**THOMPSON
STANBURY
ASSOCIATES**

NORTH WEST RAIL LINK (EIS no 2 App. No SSI-5414)
CHERRYBROOK RAILWAY STATION
FRANKLIN ROAD
CHERRYBROOK

Figure 6.12 Cherrybrook Station - Indicative vehicle and pedestrian movements

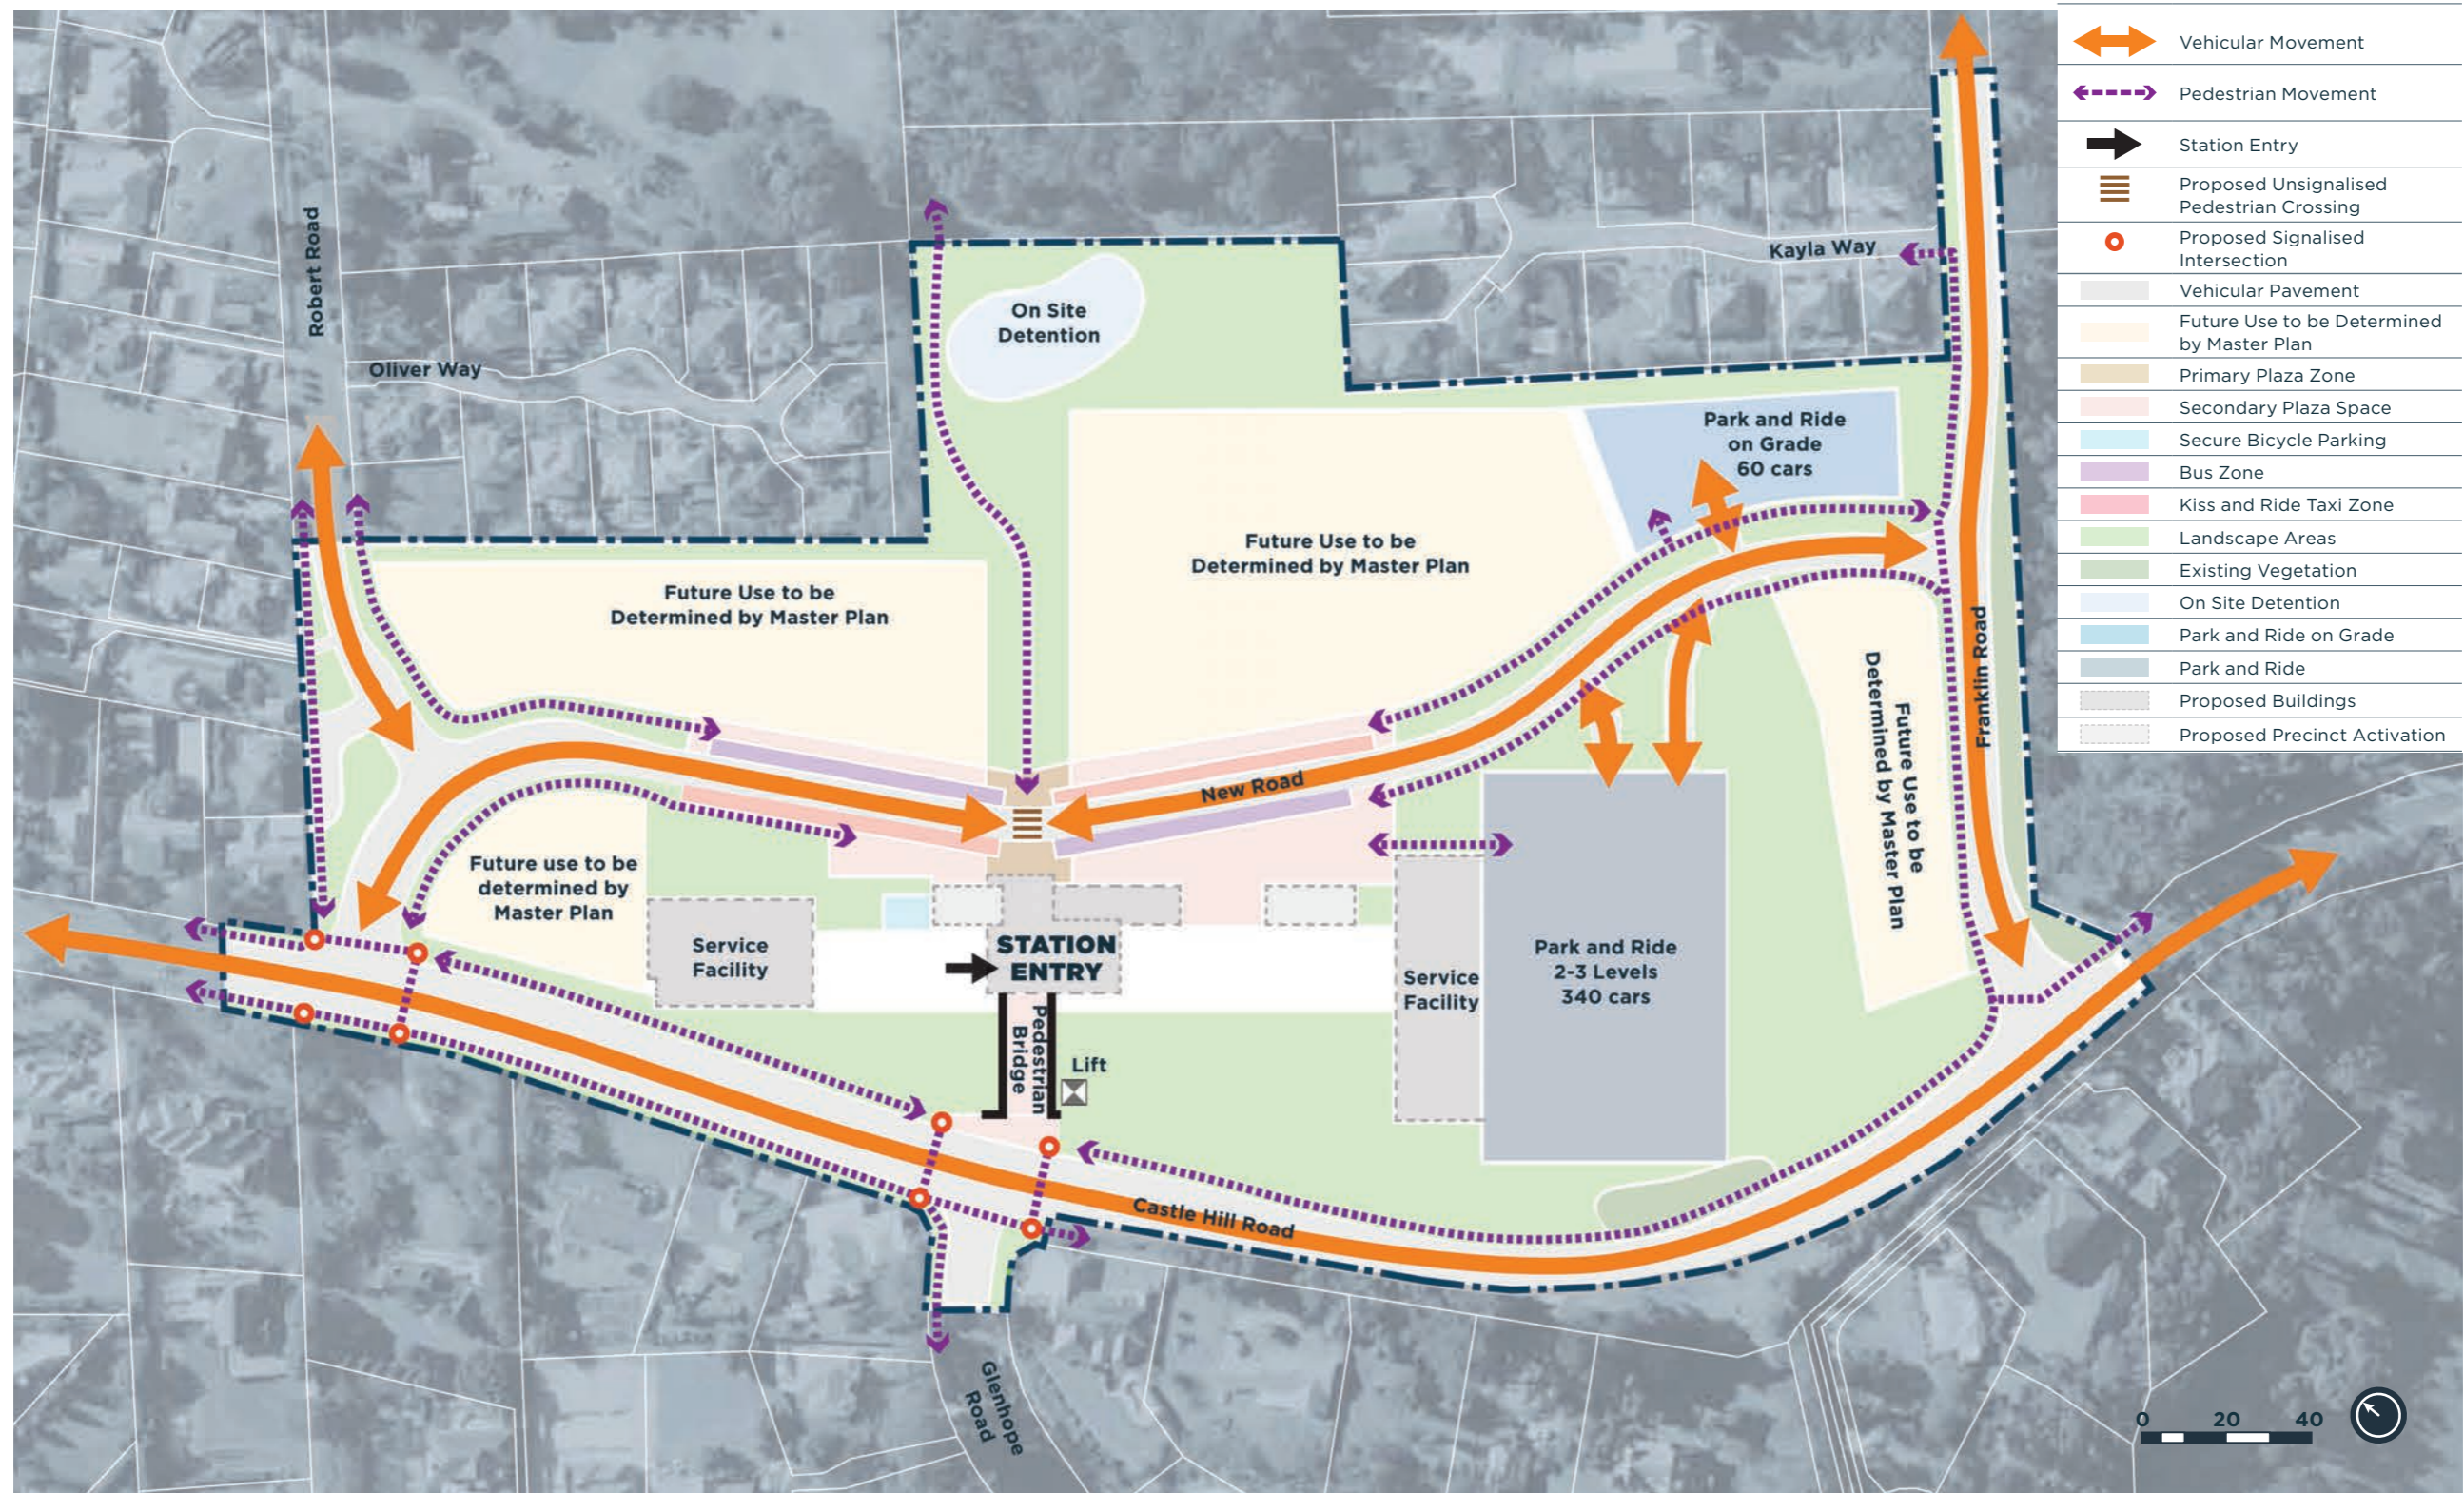
Figure 9.1 of the EIS document shows details of bus and vehicle access routes to and from the Cherrybrook Railway station. It would appear that both Franklin and Robert will share the access for both public vehicles utilising on street bus zones and private vehicles utilising the park-and-ride facilities. On street bus zones are to service bus movements entering from the east from Franklin Road and entering from the west from Robert Road with exit movements for westbound buses via the link road to Castle Hill Road in the eastbound bus movements to operate via Franklin Road to Castle Hill Road.

The proposed arrangement will increase both bus movements on Franklin Road along with private vehicle access to the park-and-ride facility as well as increasing movement on Roberts Road over and above that which currently exists. Whilst the impact of such movements will be significant over both roads, the impact on Franklin Road due to its alignment and frictional impacts (notwithstanding the localised widening to be provided on Franklin Road in the vicinity of the link road to this railway station) the overall impact on Franklin Road will be to provide unacceptable service levels on the remaining section of Franklin Road particularly in the vicinity of the high school and Inala learning facility.

It is proposed that to facilitate access to and from Castle Hill Road that a signalised junction be provided with that road and the new access link road along with modification to the existing Franklin Road junction to permit a left turn entry to Franklin Road from Castle Hill Road. These modifications are intended, it is assumed, to ensure that bus movements servicing the railway station do so without requiring bus movements to undertake turning manoeuvres but simply to drop /pick up and continue in the same direction.

Whilst this arrangement would seem to best suit bus connections with the railway station, it does lead to number of issues which directly impact on existing users as well as properties on Franklin Road in particular. Such impacts are:

- Despite localised widening on Franklin Road introduces additional bus movements as well as general traffic on a road with a substandard alignment and width
- Generates additional pedestrian conflicts with existing secondary school and Inala facilities
- Makes little or no provisions in the master plan to accommodate the above items associated with increased flows and pedestrian conflicts and safety over Franklin Road
- Provide increased traffic movements at Franklin Road with Castle Hill Road at a junction where site distance is restricted and where increased traffic movements will likely lead to increased accidents (the original reasoning behind the historical decision to partial close the junction, it being a prelude to its planned eventual full closure at the time to reduce the risk of accidents)

- Remove bus movements from Franklin Road along with Roberts Road except for existing school services.
- Importantly give consideration to rerouting all route buses from the local roads proposed for reasons of safety consideration due to the inability of the narrow roadways to accommodate two way bus flows as well as the impact on general residential and educational facilities amenity.

- On these local road routes, discourage through commuter trips on both Franklin and Roberts Road in preference for greater use of the higher order collector road County Drive along with the state road Castle Hill Road to better service rail patrons directly and without intrusion into the existing residential precinct.

- Confine all vehicular access to the railway station to the western end of the link road onto Castle Hill Road at which signal control is proposed and at which point sight distance far surpasses that at available at Franklin Road junction with Castle Hill Road .

- Restrict all access to and from the Cherrybrook railway station to the link road to the western end only providing a turnaround facility in the link road adjoining the bus set down/pick up areas to enable all incoming buses to the station to turn around and exit to Castle Hill Road at the traffic signals

- Maintain the current arrangement with respect to Franklin Road restricted access to Castle Hill Road and eliminate the left deceleration entry proposal which is to be located within a tight curve and whereby left turn exiting traffic from Franklin Road is subjected to further restricted sight distance by the auxiliary lane

- Ensure that ample pedestrian facilities are provided over Franklin Road to accommodate both existing residents needs as well that projected by the railway station to ensure safe crossings over Franklin Road,
